Our ref: DOC21/736004  
Senders ref: SSD-15001460

**Subject: EES comments on Environmental Impact Statement for Hawkesbury Centre of Excellence – SSD-15001460 – 2 College Street Richmond**

**Subject: EES comments on Environmental Impact Statement for Hawkesbury Centre of Excellence – SSD-15001460 – 2 College Street, Richmond**

Figure 6: Proposed Site Plan

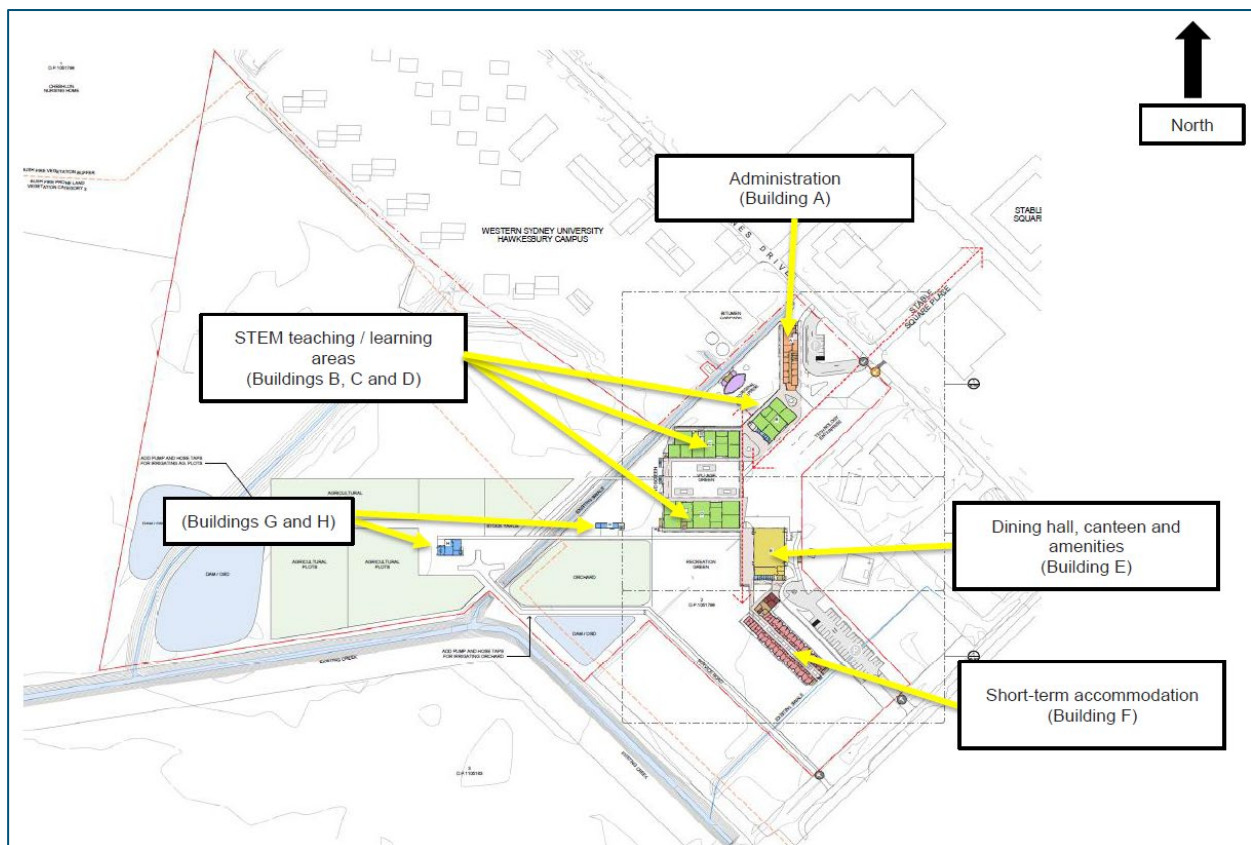
Comparing the Proposed Site Plan in Appendix D with Figures 11, 14 and 15 from the BDAR shows PCT 835 – remnant canopy and hollow bearing trees occur where it is proposed to locate agricultural plots and a dam/OSD and that the remnant canopy is to be impacted. EES seeks clarification as to whether the proposed agricultural plots and a dam/OSD can be relocated and/or reconfigured on the site to avoid and/or minimise clearing of the PCT 835 – remnant canopy and the hollow bearing trees. While EES acknowledges the vegetation in this zone is degraded, all efforts should still be made to avoid impacting endangered communities and threatened species habitats, unless such losses can be adequately justified.
